From: David Seaman [REDACTED]
Sent: 28 February 2017, 15:55
To: Simon Davis
Cc: 'Mike Wigmore (mikewigmore@hotmail.com)'; Lizard Landscape Design - Landscape Architects and Planners
Subject: FW: LLD1029 - BE/180/16/PL - North Bersted, Bognor - Planning Consultation
Importance: High

From: Lizard Landscape Design - Landscape Architects and Planners [REDACTED]
Sent: 28 February 2017 15:27
To: David Seaman <[REDACTED]>
Cc: Mike Wigmore [REDACTED]
Subject: LLD1029 - BE/180/16/PL - North Bersted, Bognor - Planning Consultation

North Bersted, Bognor - Planning Consultation

Project title			
North Bersted Street Bognor, West Sussex			
Drawing title			
Tree Constraints Plan			
Scale	Drawn	Date	
1:100@A1	GS	05.10.16	
Approved		JJ	
Drawing No	Revision		
LLD1051 / 01	00		
CAD Filename			
LLD1051/01/CAD

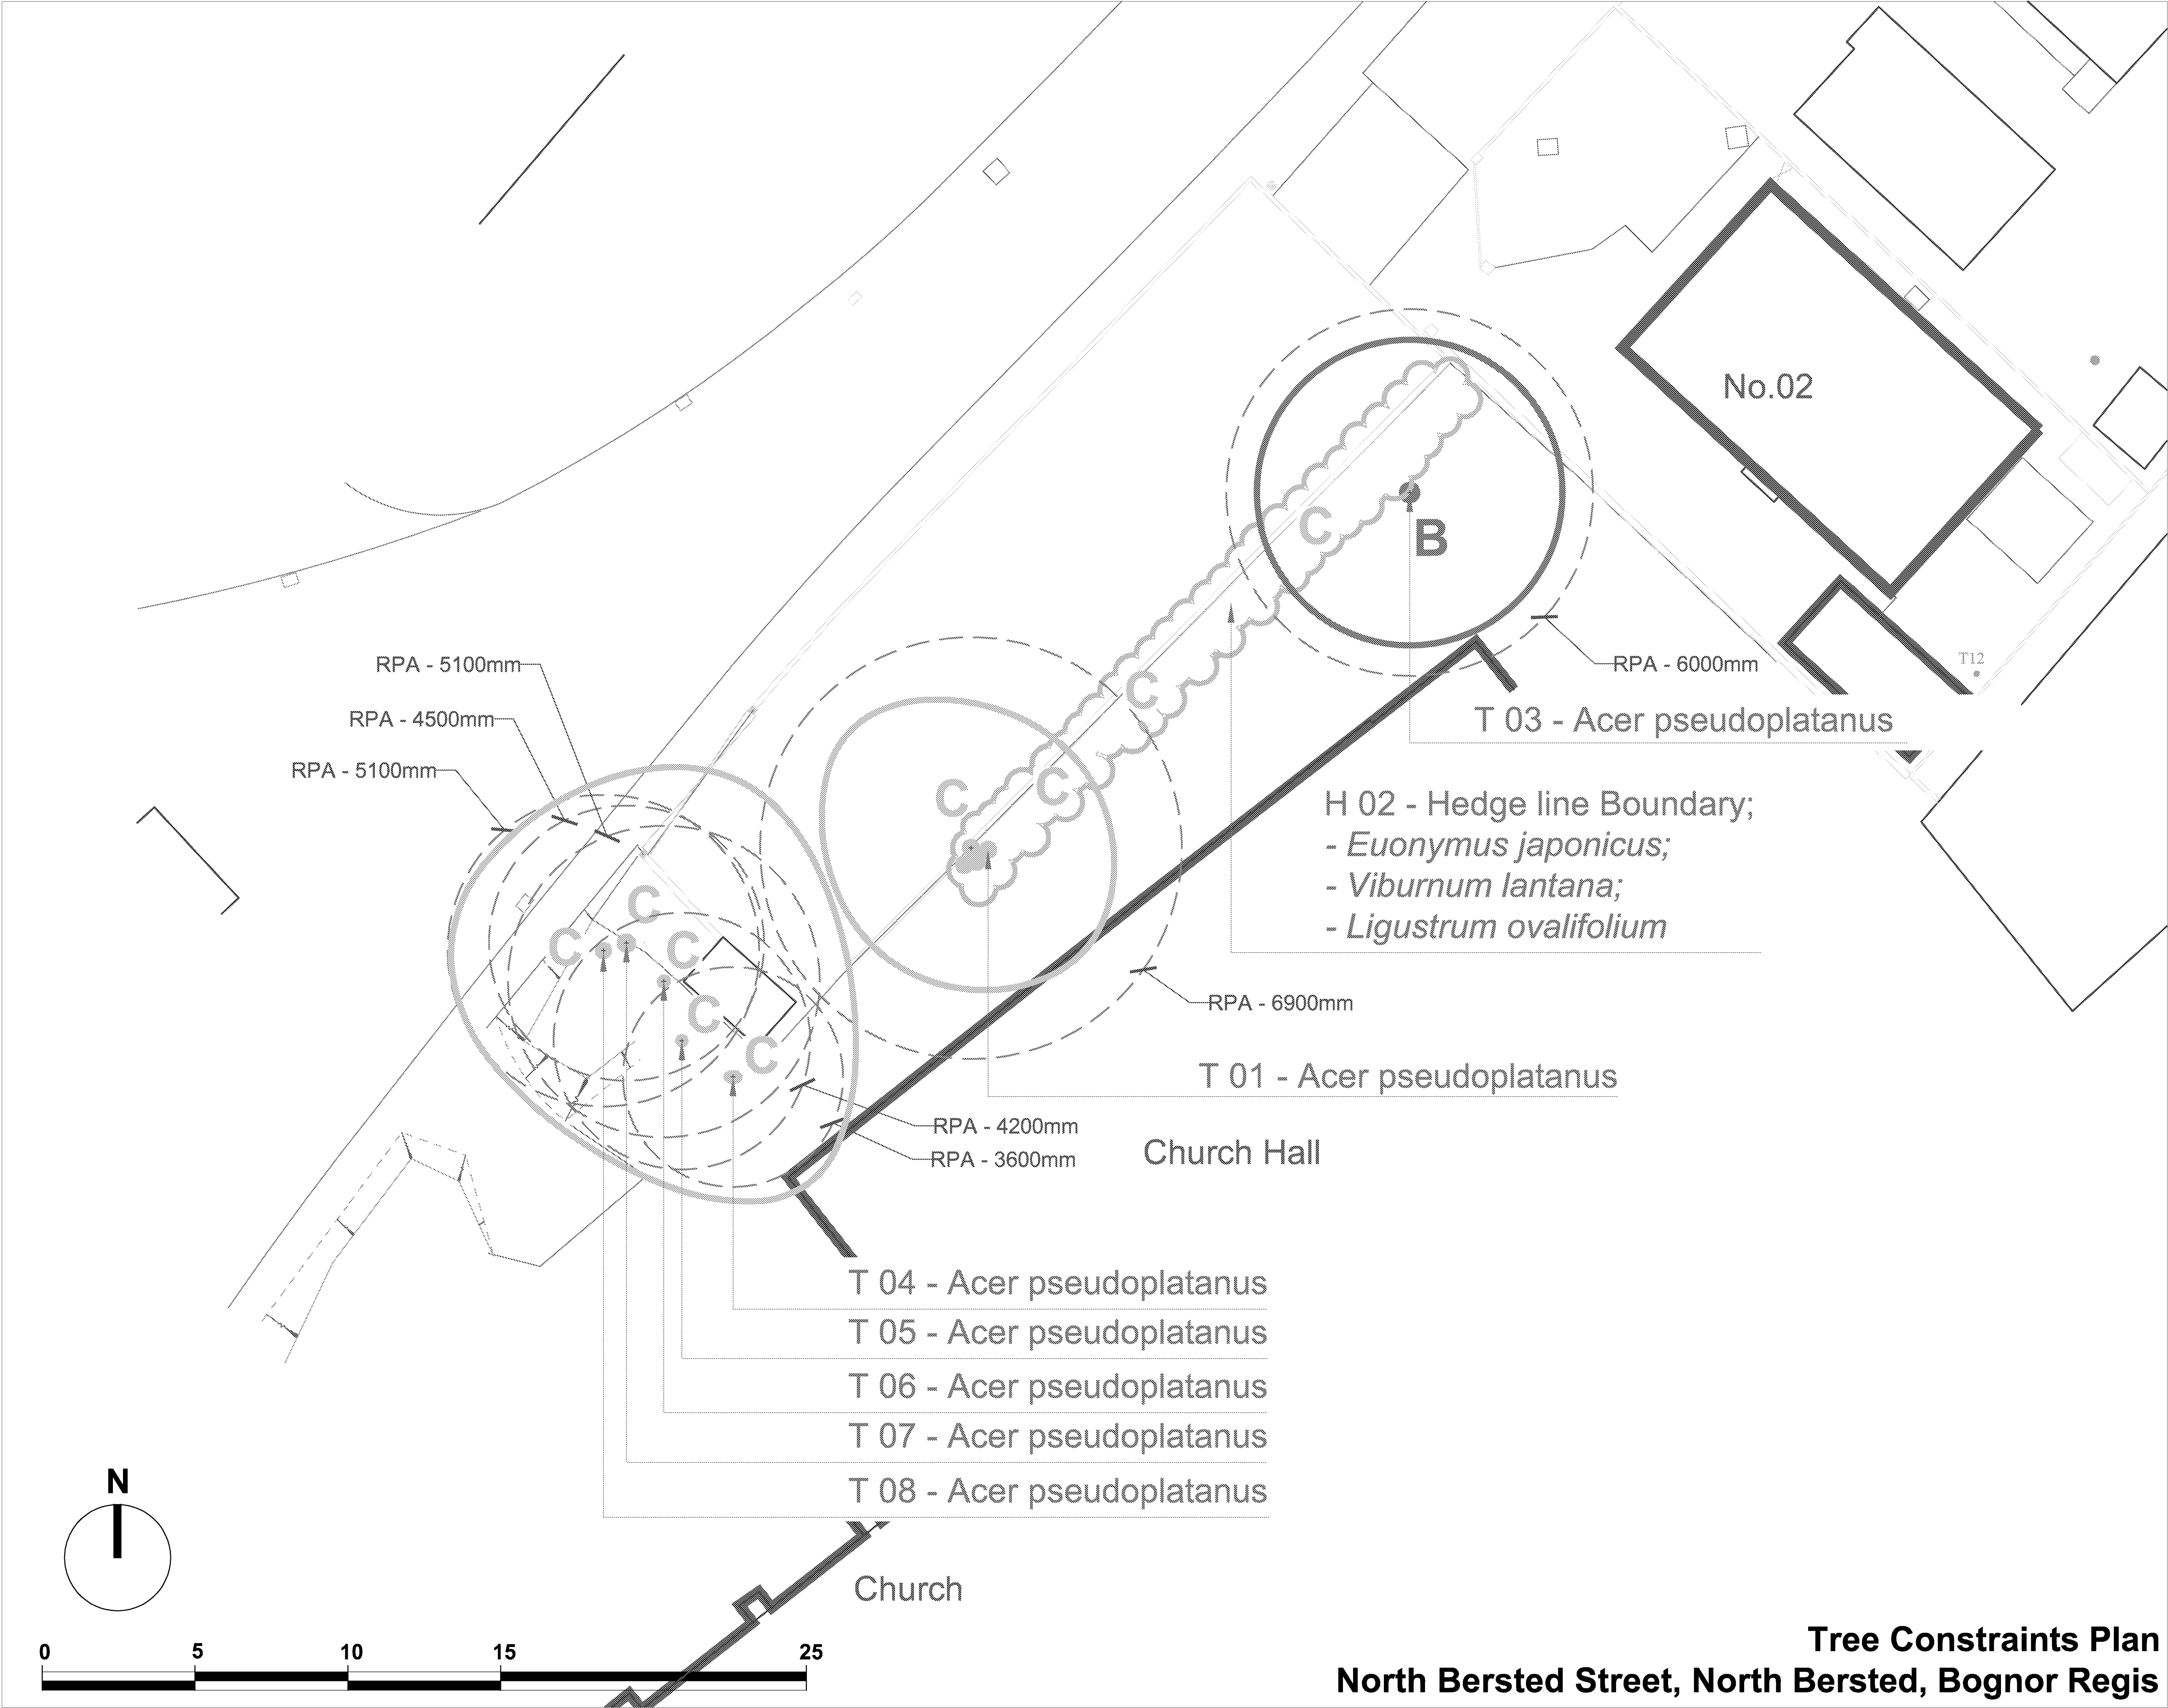
In response to the comments made by the Council's Arboriculturalist, I have highlighted the following points below;

There are 7 no. Sycamore trees surrounding the site area to the southern and western edges. The southern edge of the site is also lined with a shrub hedge line. The trees are not of good quality and condition; and the trees to the western site edge are 'mature' and not particularly in a good condition being remnant self-seeded sycamore. The tree officer's reports states that these trees are 'young' (*Photograph attached*). These trees to the western edge of the site area are also located some 14.0 metres from the western elevation of the proposed dwelling house, where an area has been provided as a suitable private garden space between the development and the existing trees to the western site edge which should provide adequate distance between the development and existing line of trees. The proposals make use of a small pocket of land for residential use whilst also maintaining the existing tree cover to the site boundaries.

All of the trees are also located behind 1.0 metres height approximately retaining walls to the edges of the site area and their tree root protection areas would not be impacted by the development proposals due to the height difference surrounding the southern and western edges of the site, being higher than the site area. The two trees to the southern edge of the proposals are close to the proposed building but are located and set back from the edge of the retaining wall where their root zones would remain unaffected. It should be possible to agree tree surgery work proposals for these self-seeded low quality sycamore trees to the northern tree canopy aspect in close proximity to the proposed new building in order to achieve the development scheme.
